Inspector's Report See pictures for 769 ABP-302770-18

Whether the conversion of existing vacant office space and seminar room to a one-bedroom studio apartment is or is not development or is or is not exempted development

Tí Choinn, Gleann na Rí, Murrough, Galway.

P/DC/3/15/18

03 South Elevation
Scale: 1:200

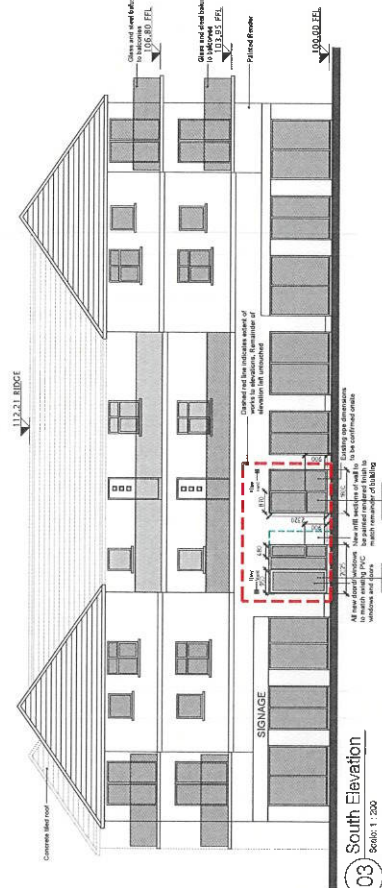
- It is proposed to convert ground floor seminar room / office space to a one-bedroom studio apartment and connect to existing services. It is proposed to carry out alterations to the existing windows on the southern elevation serving the office space, these alterations are considered to be non-material

01 Ground Floor Plan
 Scale: 1:100
 Unit Building area 750.88sqm
 Proposed volume area: 104 sqm

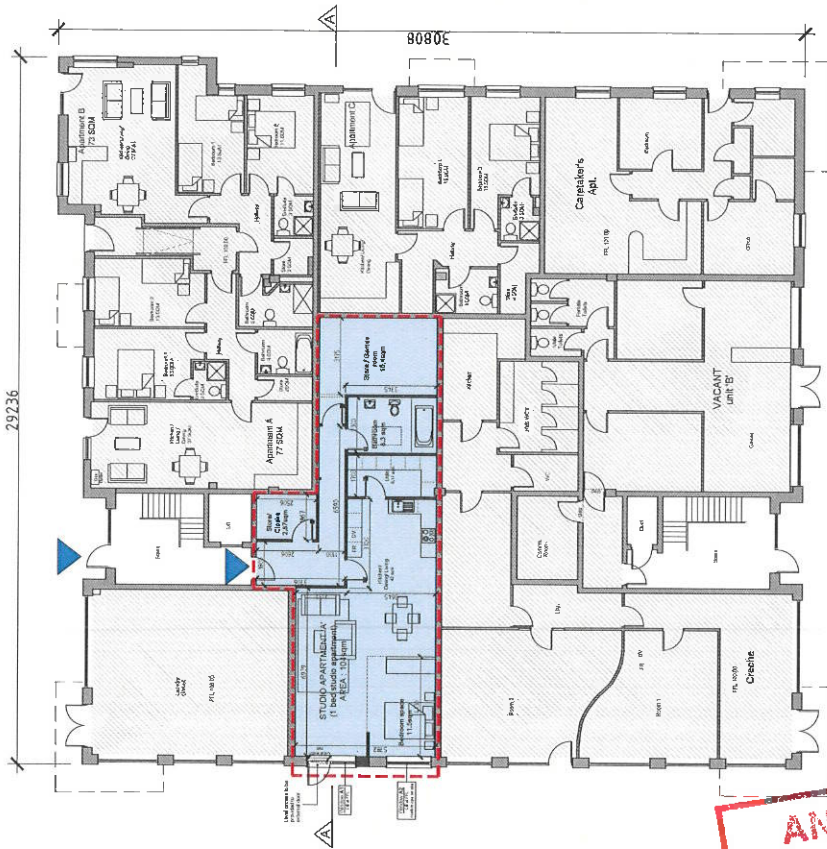
- 9.2.16. Per 6(d)(vi) - that the proposed dwelling floor areas and storage spaces would comply with the minimum floor area requirements and minimum storage space requirements of the Sustainable Urban Housing: Design Standards for New Apartments — Guidelines for Planning Authorities, a requirement under paragraph (d) (vi) of the regulations, is not in dispute. It is noted that there is no outdoor private amenity space available for the proposed two-bedroom apartment but this is not a requirement of the exemption.

- 9.2.17. The requirement under paragraph (d) (vii) that rooms for use, or intended for use, as habitable rooms shall have adequate natural lighting, is not addressed in the submission. Since the Sustainable Urban Housing: Design Standards for New Apartments — Guidelines for Planning Authorities, is referred to under paragraph (vi) of the 2018 Regulations, it would be reasonable to consider its provisions would apply also to paragraph (vii).

- 9.2.19. From the plans provided, it appears that the single habitable room proposed, (a room used for living or sleeping purposes but does not include a kitchen that has floor area of less than 6.5 square metres) would not have adequate natural lighting. It is noteworthy that an internal room, nominated as a store or games room, of 15.4 sq m, would have no natural light and no window.
